Response to Issues – City of Sydney

80-88 Regent Street, Redfern – SSD 7080

Initial submission

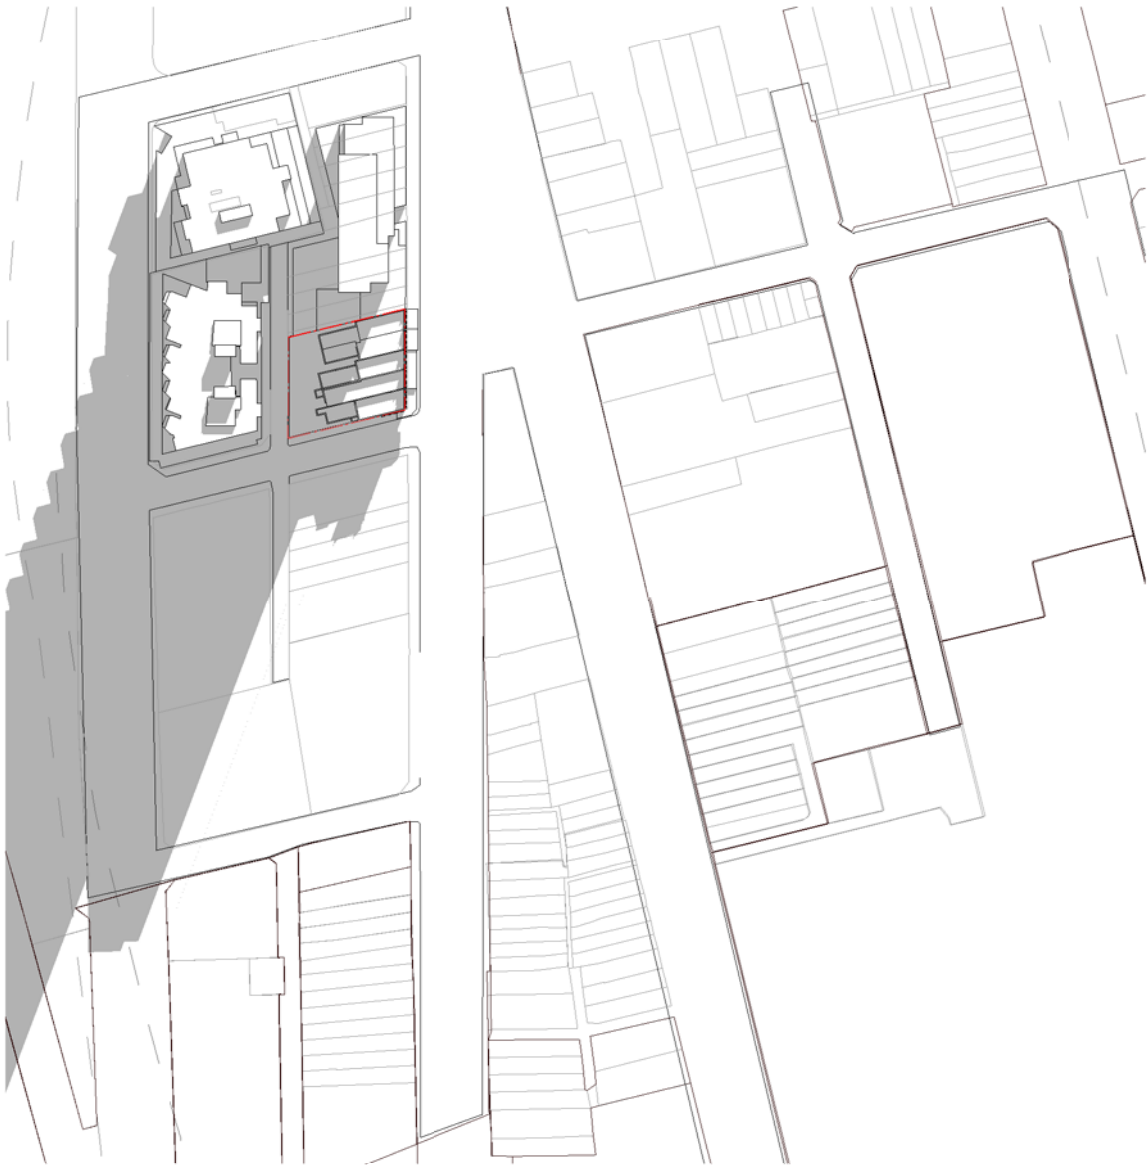
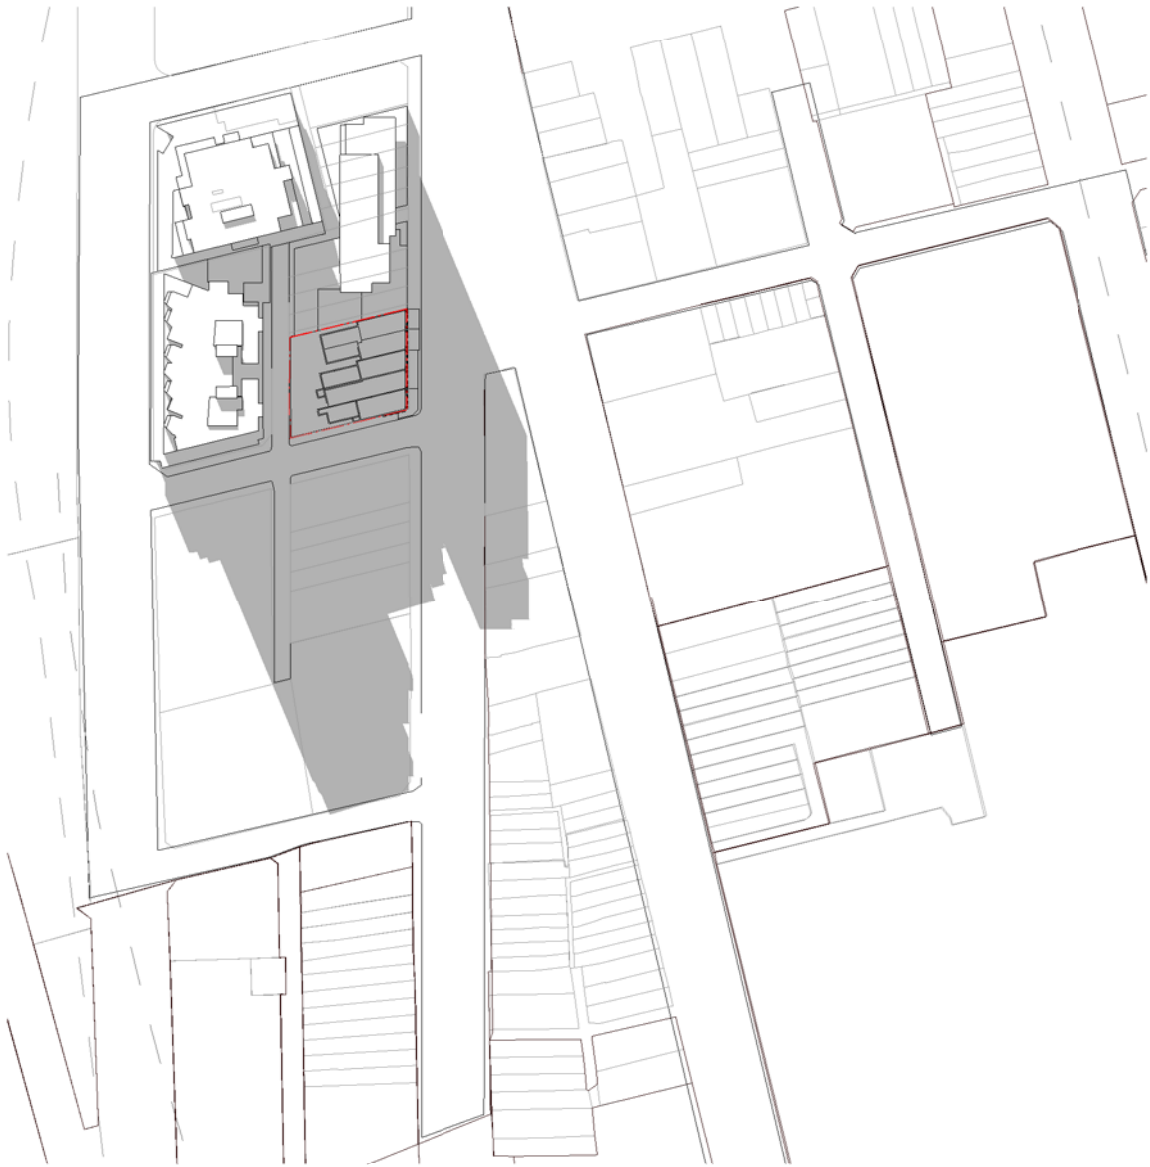
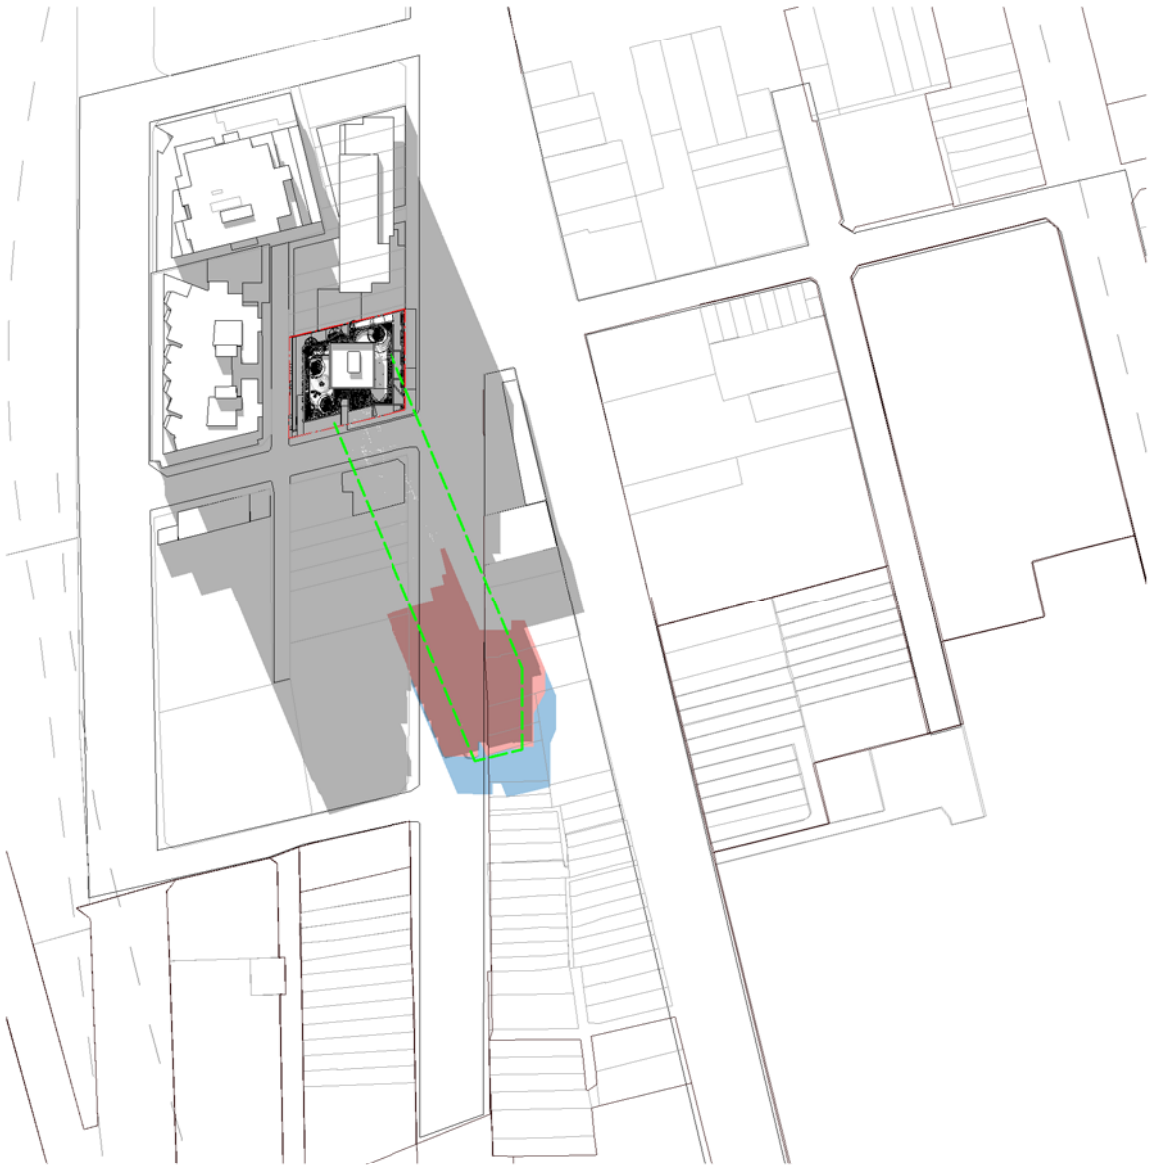
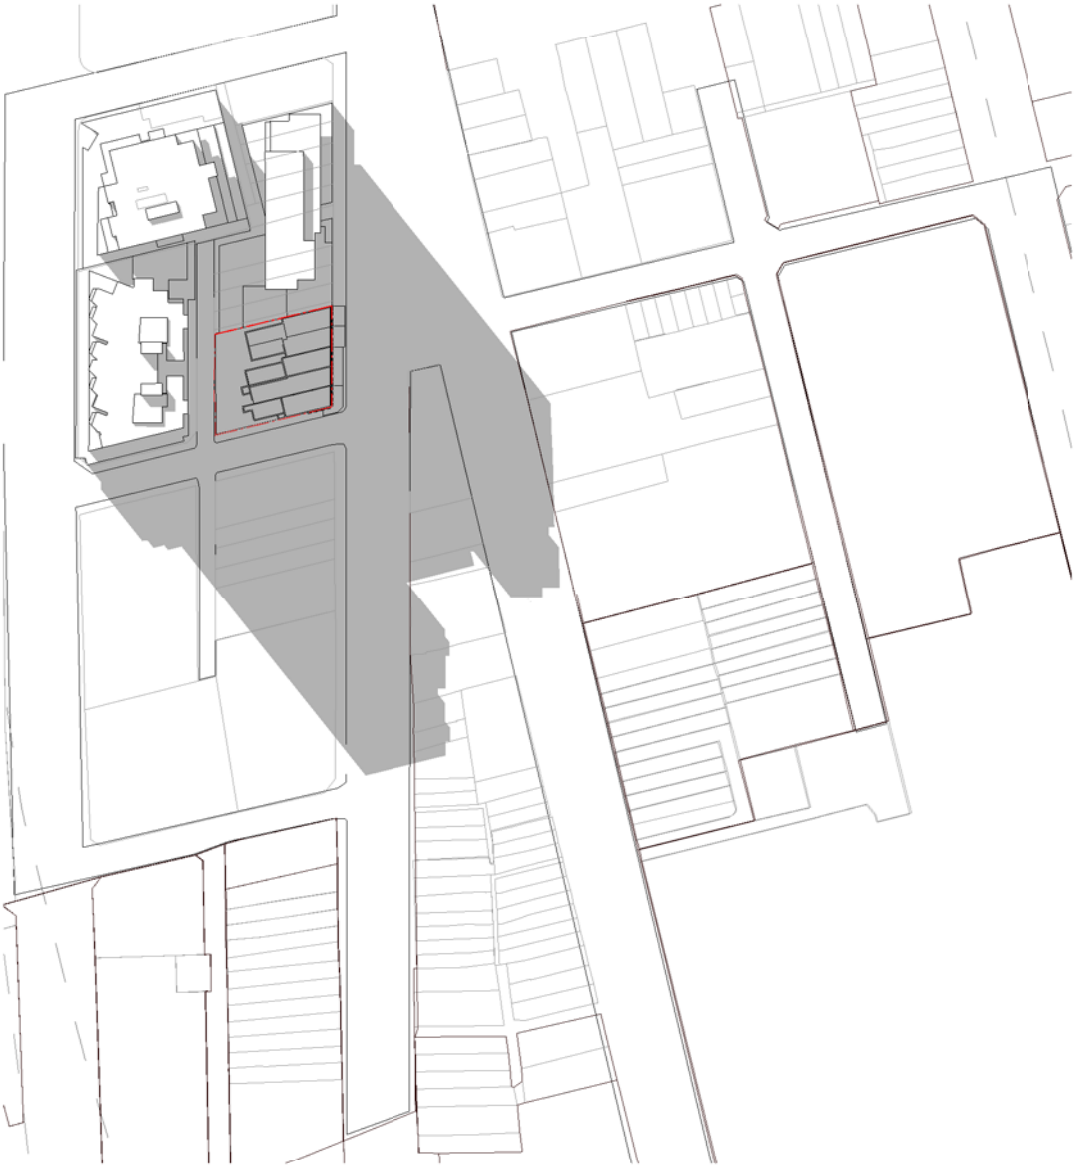
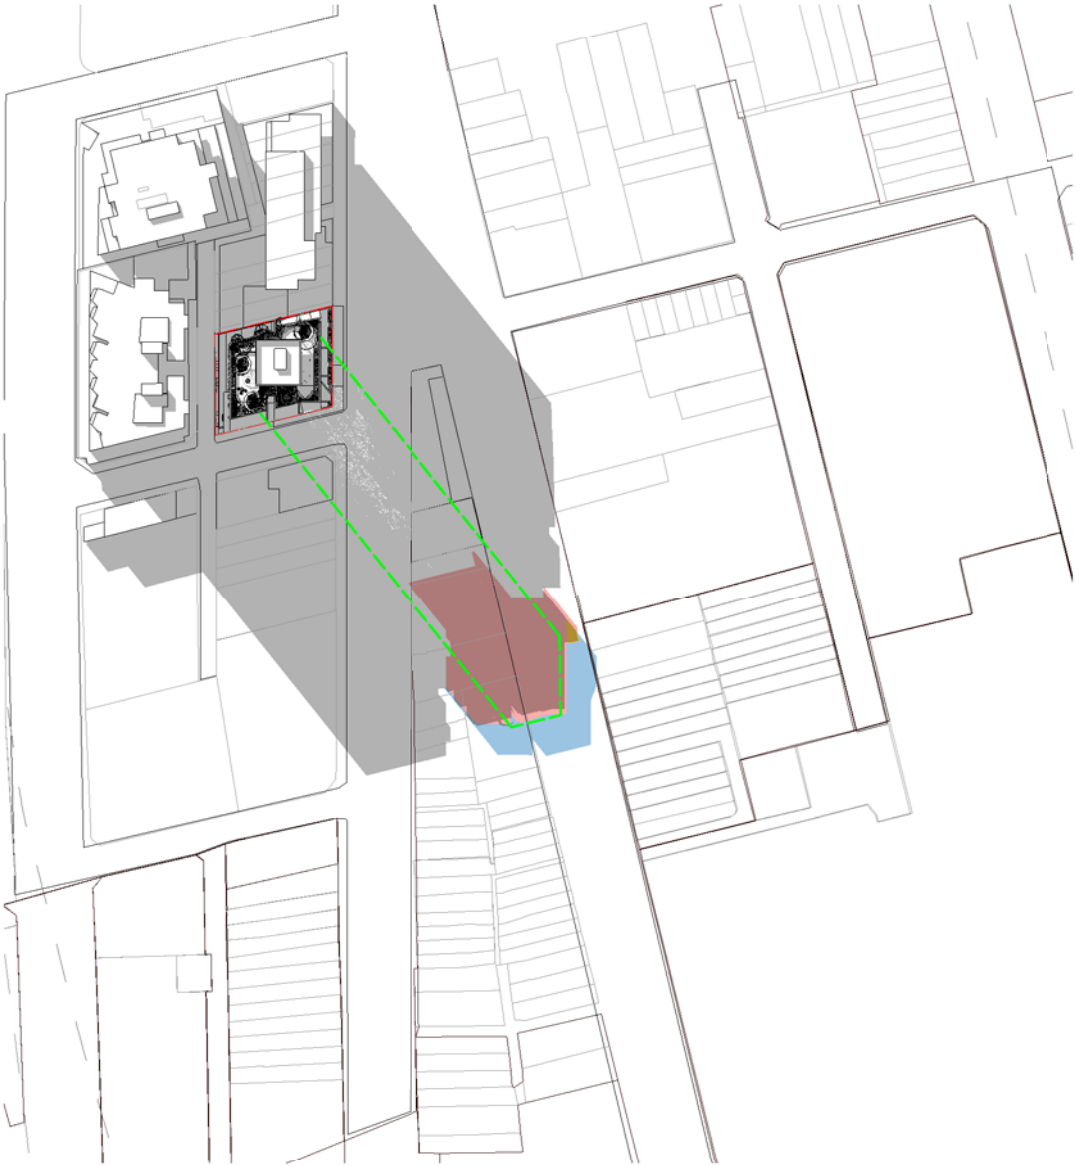
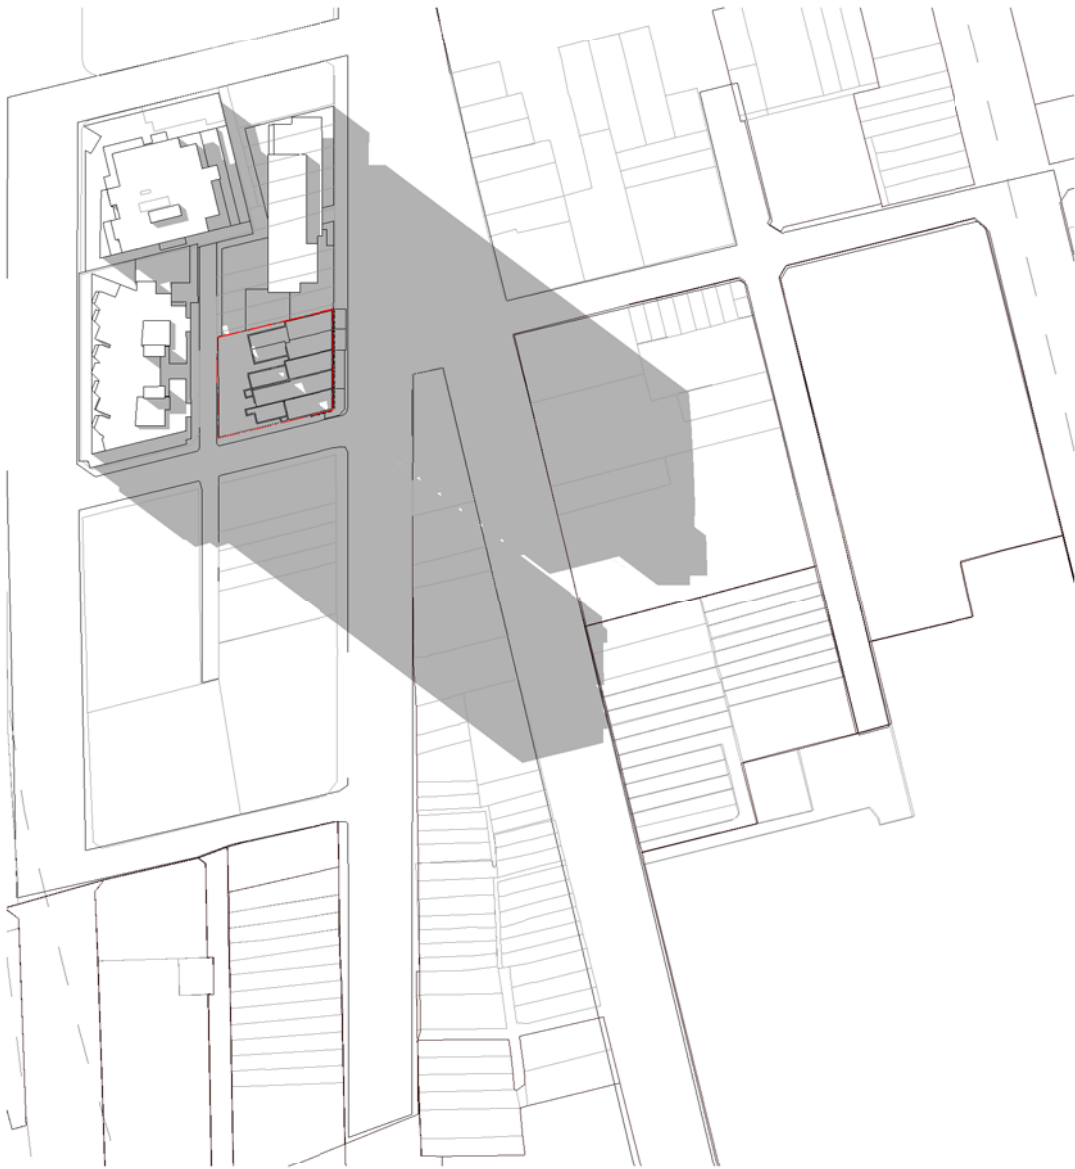
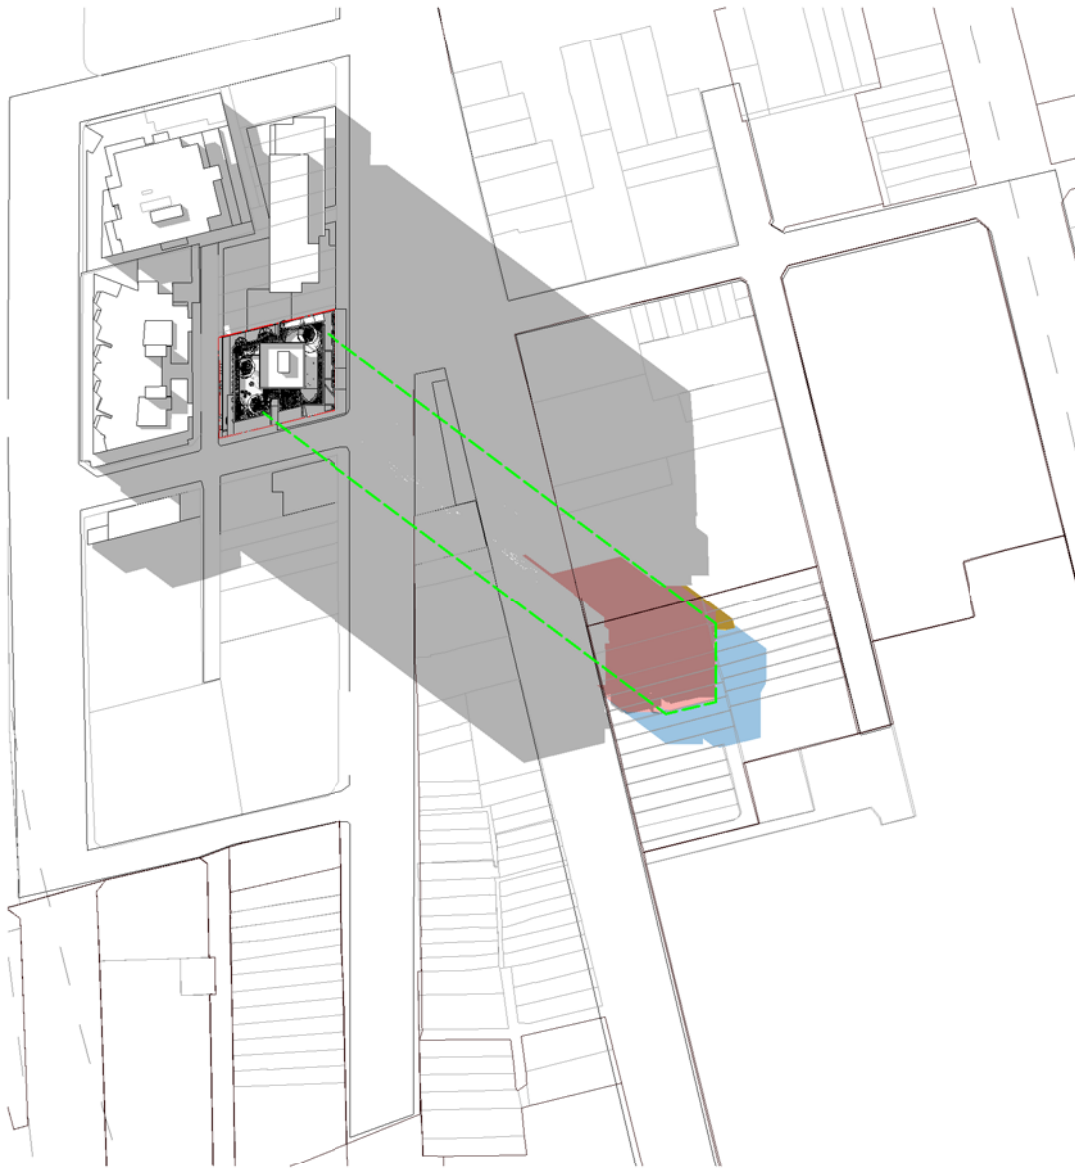
17. While the controls envisaged an 18 storey building, the proposal presents as a 20 storey building, increasing overshadowing impacts, particularly to the conservation areas between Cope and George Streets in the afternoon midwinter. There may also be additional view loss to residents in the adjoining residential building immediately to the east and northeast.	The height of the proposal has been reduced. The two mezzanine levels have been removed. Overshadowing analysis and an assessment of the impacts on views has been undertaken,	Refer to Sections 4.1, 4.7.1 and 4.7.2 and Architectural Drawing Package at Attachment 1

18. It is difficult to determine the extent of overshadowing and view loss that may be caused by the additional two storeys and lack of upper level setback. While the controls assume that there will be some impacts, the impacts should be limited to those anticipated by the controls.		
	<u>Recommendation</u> <ul style="list-style-type: none"> A careful review of the proposal is required to determine additional overshadowing and view loss impacts of the proposal as follows: <ul style="list-style-type: none"> ensure that there are no additional impacts created by the additional 2 storeys by comparing the proposal against a complying 18 storey scheme; ensure that there are no additional impacts created by the reduced upper level setback for Levels 15 to upper mezzanine by comparing the proposal against a complying setback scheme. 		
Podium design	19. The new podium proposes a series of five, large, high arches, which appear to be an interpretation of the existing 5 terrace buildings.	The podium has been modified.	Refer to Sections 2.2, 4.2.1, 4.6,
